DEVELOPMENT REVIEW BOARD
SUPPLEMENTAL SUBMITTAL

PROJECT NO. 2020-004757

RE: RV Storage – Albuquerque: DRB Resubmission

COMMENT RESPONSE LETTER

RV STORAGE - ALBUQUERQUE
ALBUQUERQUE, NEW MEXICO
SITE PLAN
SITE PLAN

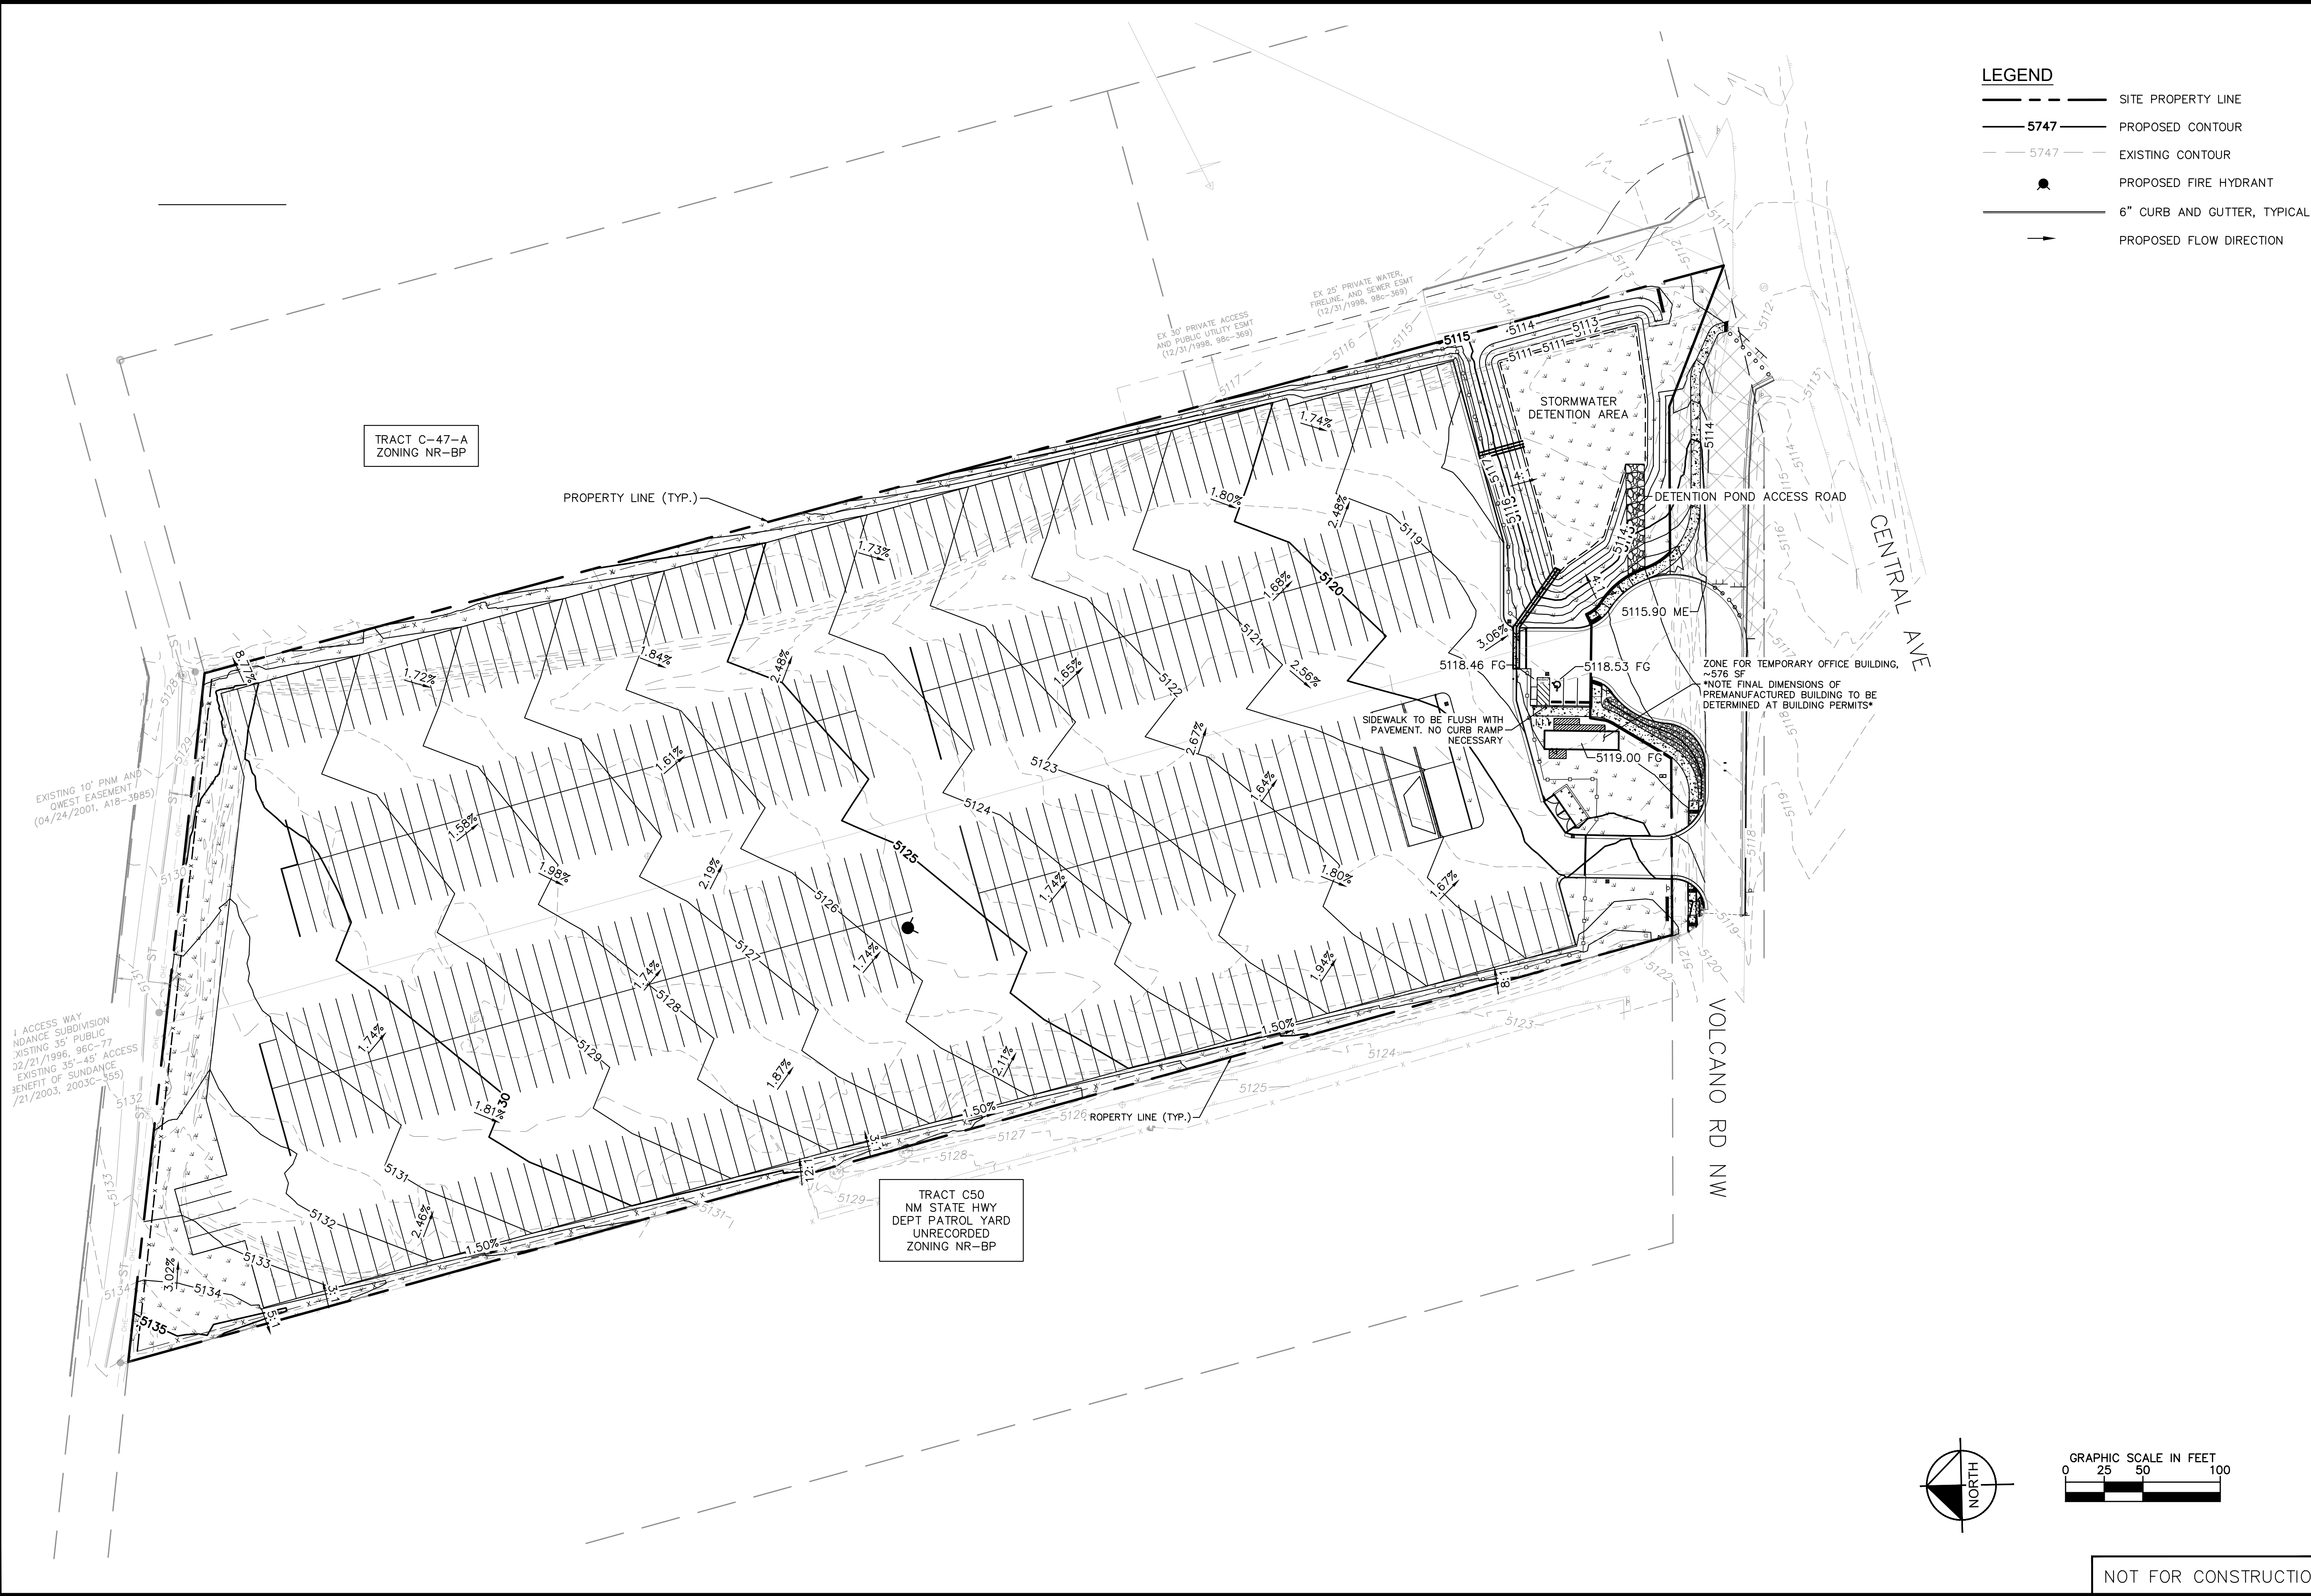
1. Actual public roadway improvements for Volcano Road shall be reviewed and approved through the City work order process. Platting action shall also be required to include all public roadway improvements within public right-of-way, including the 6-foot public sidewalk. *Add note to this effect on site plan.*
 - *Response: This note has been added to the Site Plan.*
2. Once an application for vacation action simultaneously with platting action is made, Transportation Department can officially sign off on the plans.
 - *Response: Acknowledged.*

7. 6-foot public sidewalk shall be extended to end of proposed cul-de-sac with ramps on each side of the accessway. (Add ramp details to work order plans.).

- *Response: Acknowledged. The Site Plan has been updated to include the requested 6’ sidewalk.*
8. In front of the van accessible aisle, will a ramp be required, or is the sidewalk flush with curb? Specify either way on the plan, and include ramp detail as necessary.

3. Confirm wall details.
 - *Response: It is a screen chain link fence, per IDO 14-16-5-6. Note was included in the last set (Sheet 7) to discuss it.*
4. If right-of-way is dedicated, a replat will be required.

- *Response: The sidewalk will be flush with the curb. A label has been added on the plan to clarify.*
9. On the infrastructure list, specify 6-foot sidewalk under “size” as opposed to square footage. Specify location in terms of property corners or relation to property corners.
